From: Jonathan Perks [REDACTED]
Sent: 28 February 2017 12:21
To: David Innes
Subject: P/140/16/OUT - Summer Lane Pagham

SUBJECT: P/140/16/OUT - Outline application for access only - mixed use development comprising of up to 400 dwellings, a care home with up to 70 beds, a Local Centre comprising up to 2000sqm of A1/A2/A3/D1/sui generis floorspace, provision of land for a 1FE primary school (with sufficient space to ensure that it is expandable to 2FE), provision of land for a scout hut, safeguarding of land to help link the site to the Pagham Harbour Cycle Route & other community uses including public open space & allotments with some matters reserved. This application is a departure from the Development plan

Land South of Summer Lane & West of, Pagham Road, Pagham, West Sussex

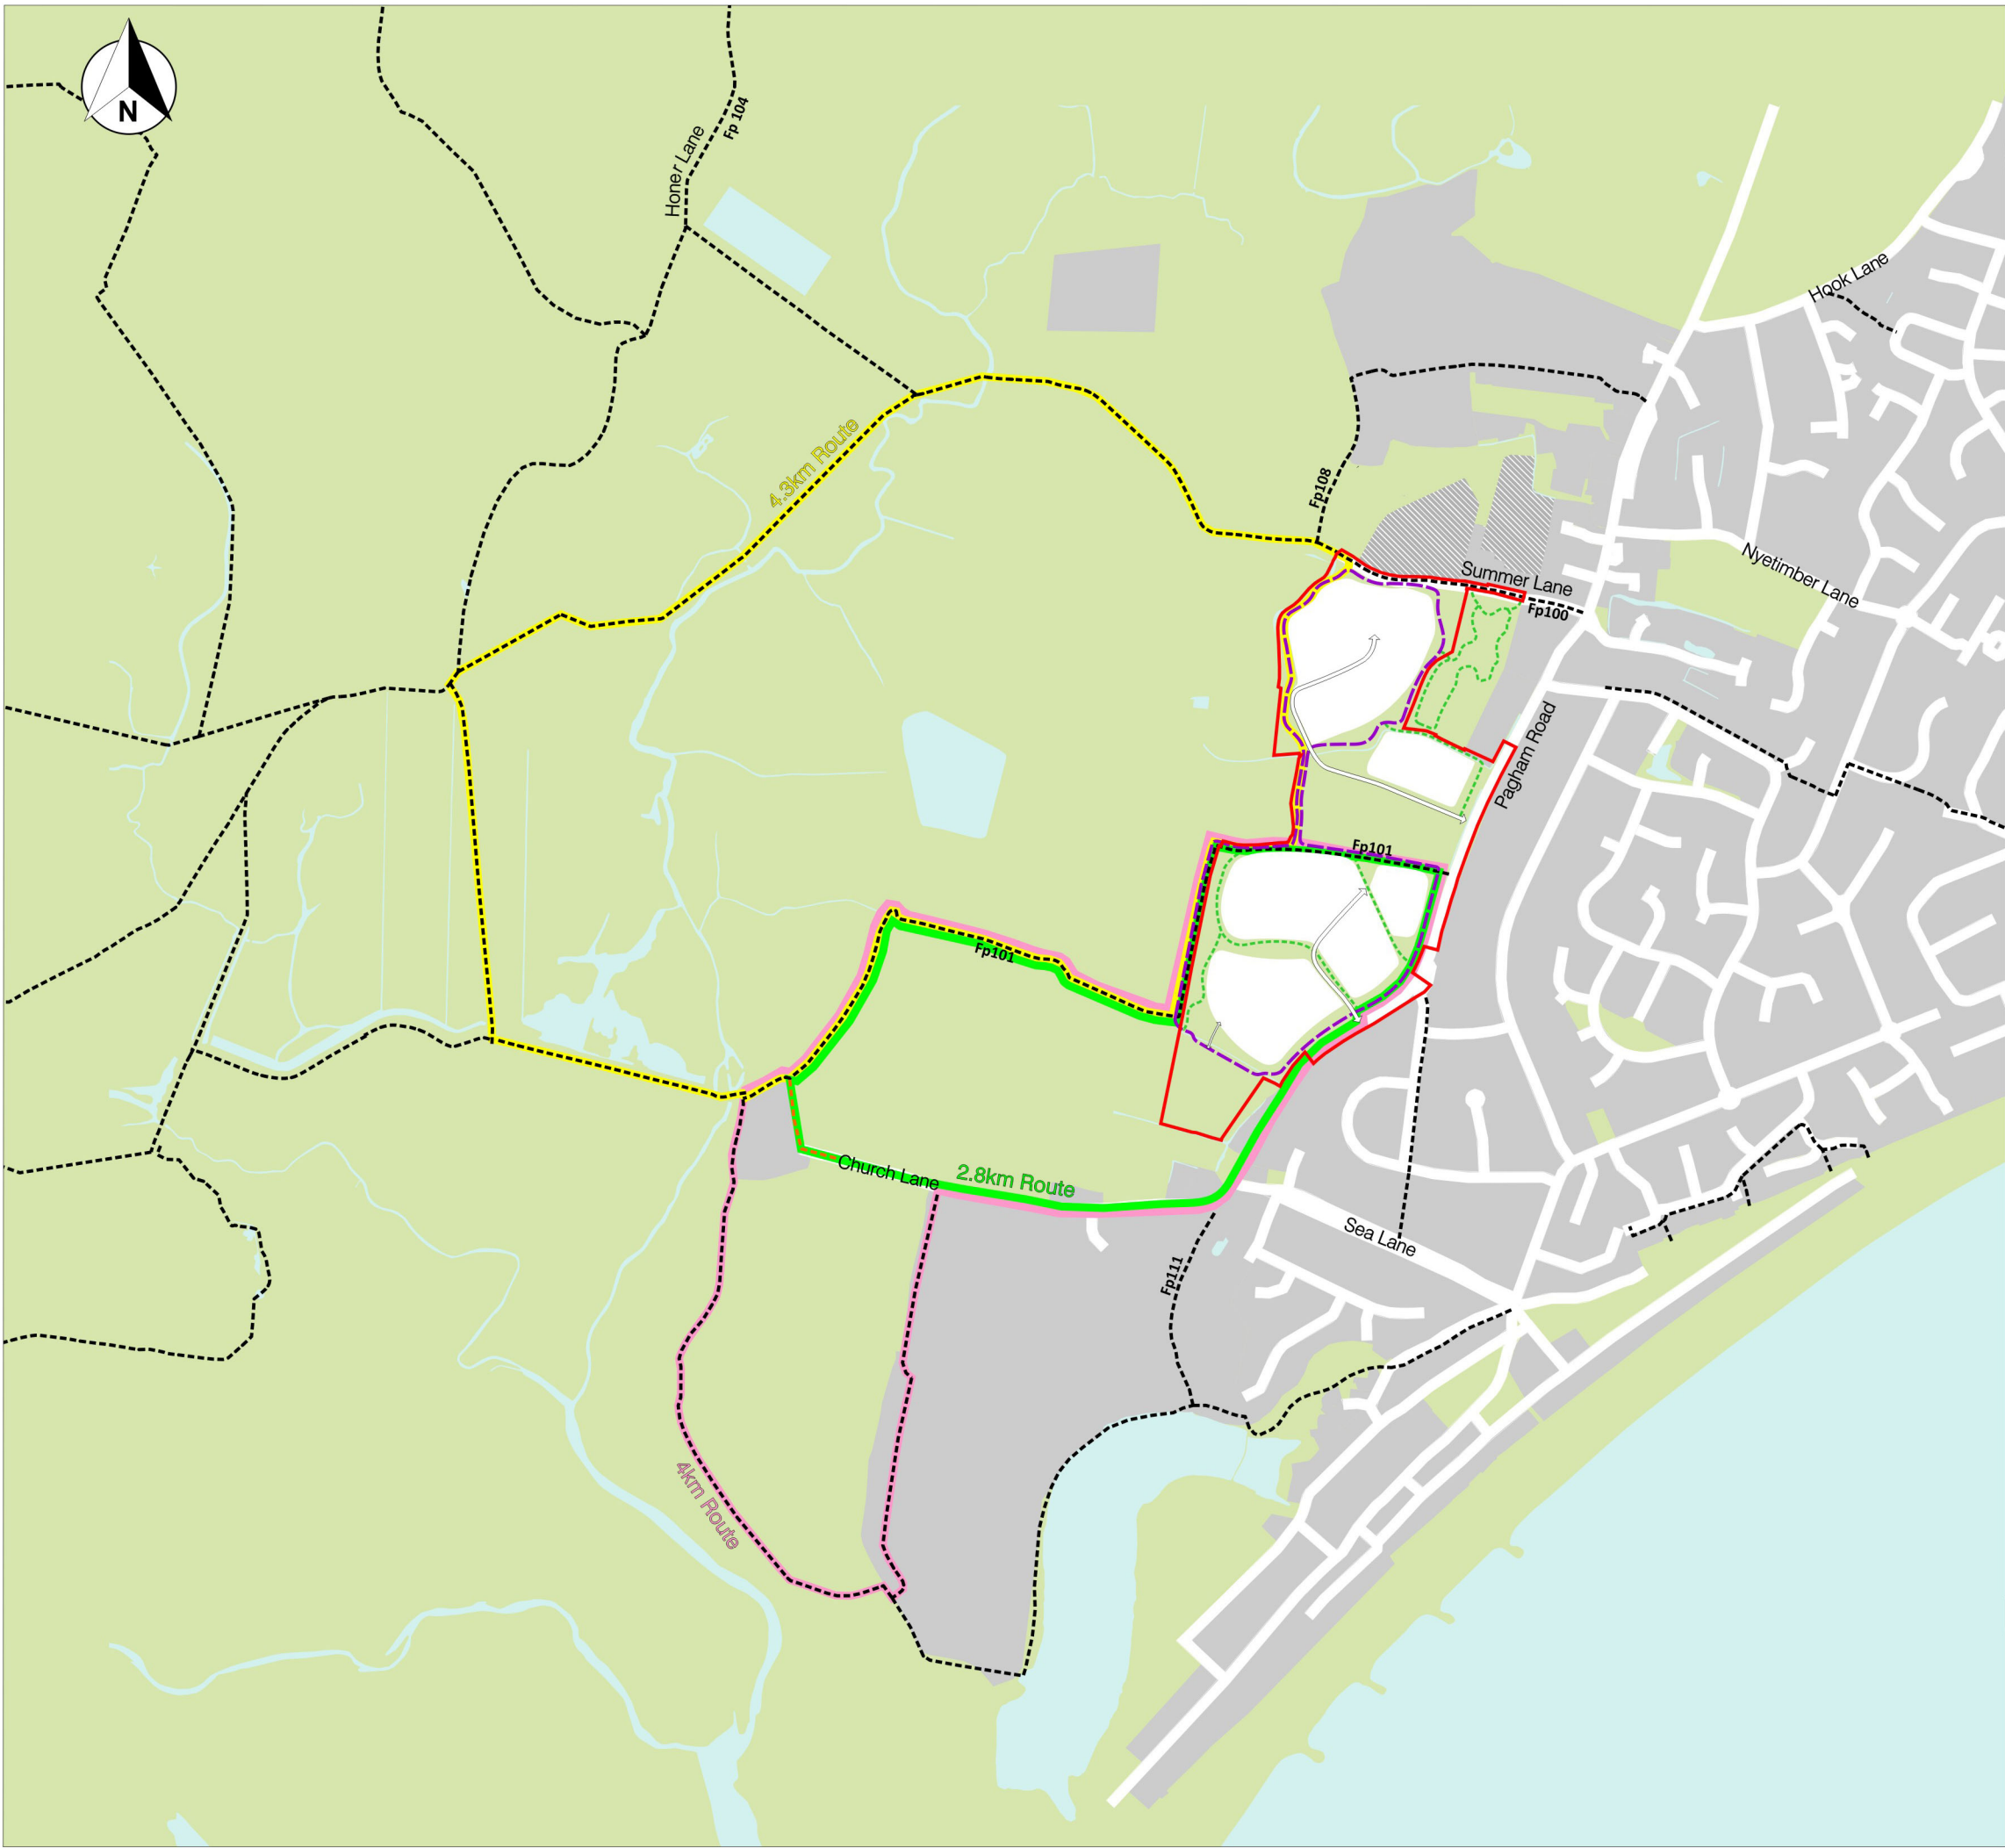
Firstly, to answer the comment given by Hunter Page in the email below concerning point 4 in PROW comments, the additional circular route from Shipverling Barn around the reservoir to join FP 101. Whilst we acknowledge this particular area is well served by rights of way, an additional circular route will be welcomed and attractive to both existing residents and new alike. This is increasingly so given the elderly demographic of the Pagham area, who may welcome shorter circuits and it spreads the expected increase in number of walkers across the area. As the land falls within the applicant's land interests, it would be within their power to gift this addition.

4. We would also like the applicant to look at creating a circular walk going north west from FP101 past Shipverling Barn turning south round the back of the reservoir to re-join FP101, this is within their power to gift. This proposed route would be of community benefit and be attractive to new residents who will inevitably looking for dog walking routes.

In terms of the response from WSCC PROW team, point 4 suggests a circular route being provided. On this matter, the proposed on-site footpaths shown within new green infrastructure (see attached 1731-L003-12) work in combination with the existing footpath network (see attached 1731-L003-11), to provide an excellent variety of circular footpath routes through different landscape characters without need for an additional loop around the reservoir outside the site application area.

A similar length of route to that around the reservoir (2.3-2.4km) can be achieved off footpath 101 around the perimeter of the application site as shown on the attached drawings, which can either be extended or reduced through a number of other inter-connecting paths including the Parish Council ANOGS area (approved under the adjacent planning permission).

To the west, starting from footpath 101, there is a longer 4.3km circular footpath route via Honer and Furze field farms utilising on site footpaths to avoid having to egress from Summer Lane onto Pagham Rd. To the south there is the opportunity to utilise a variety of existing routes to create 2.4-4.1km circular walks starting from either footpath 101 or the new site entrance to the south.

Given the availability of circular footpath routes it is considered that there is not the need for an additional loop around the reservoir outside the site application boundary.

Internal Movement Strategy

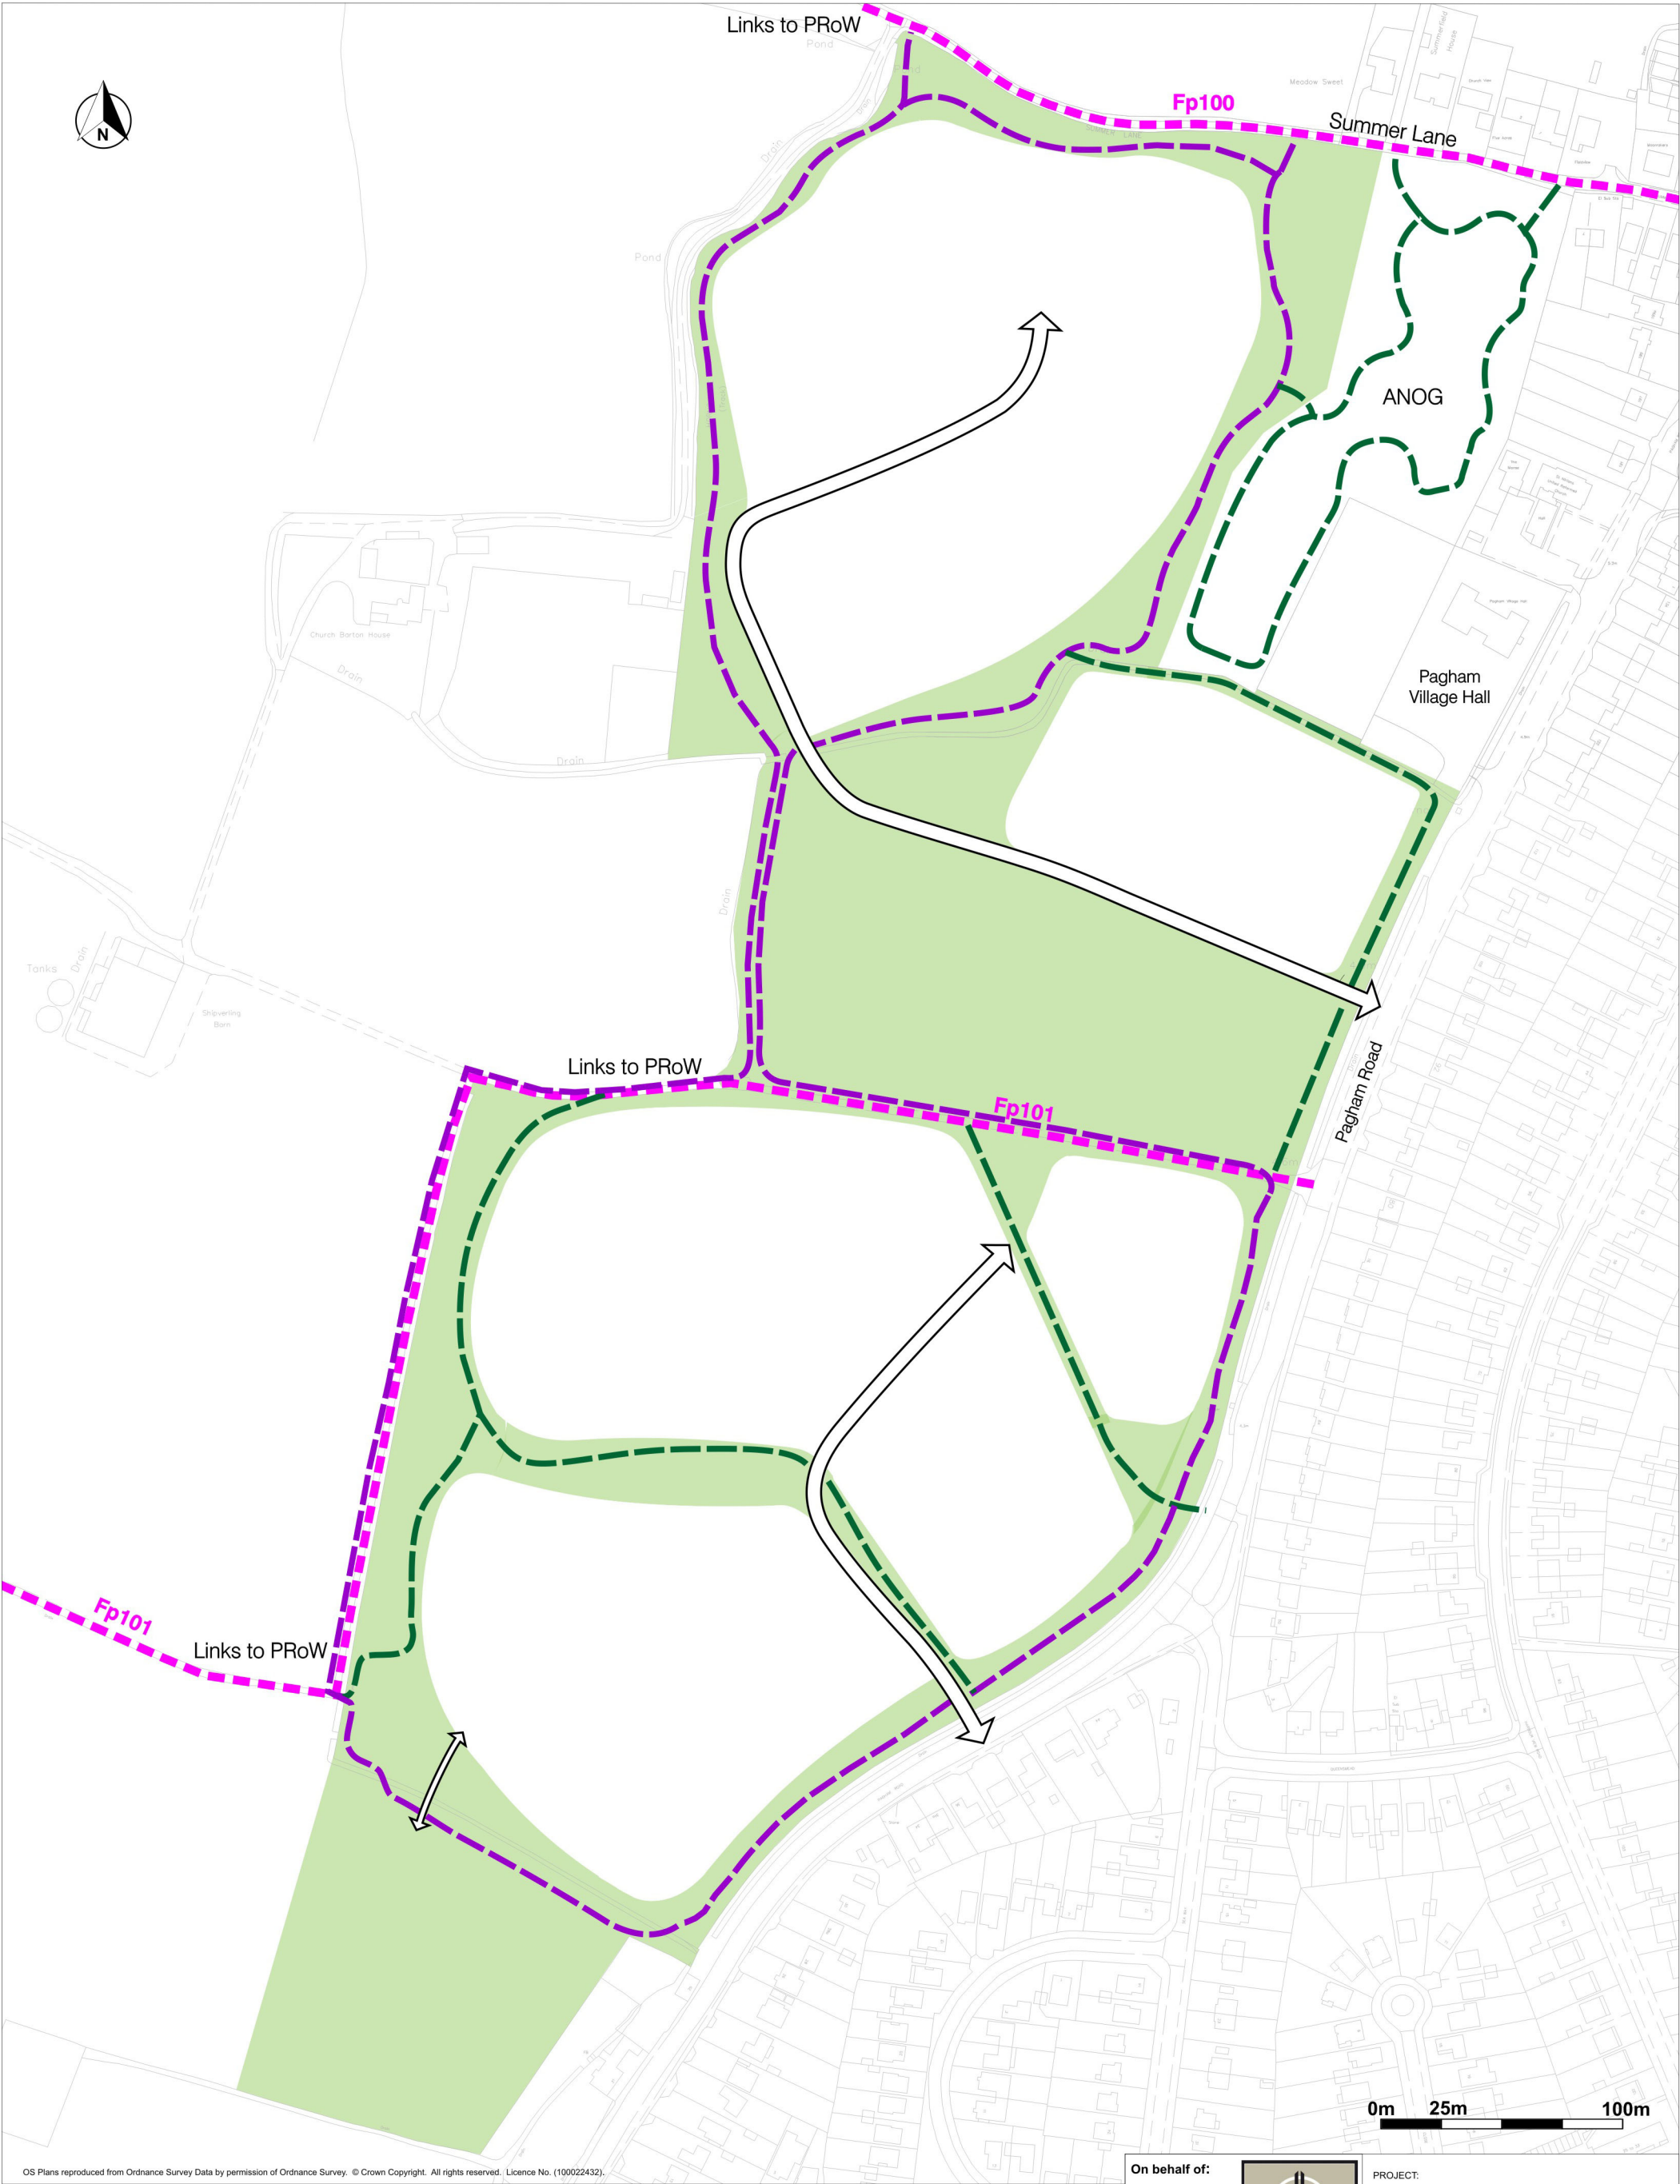
Could the applicant confirm if the section of FP 101 shown in yellow on the plan below, is part of the Proposed Primary Pedestrian route as indicated on the Internal Movement Strategy plan? It is not entirely clear on the plan if it is on the line of the footpath or within the development .

The County Council would like confirmation that future maintenance of the internal pedestrian and cycle routes within the site boundary will remain the responsibility of the applicant
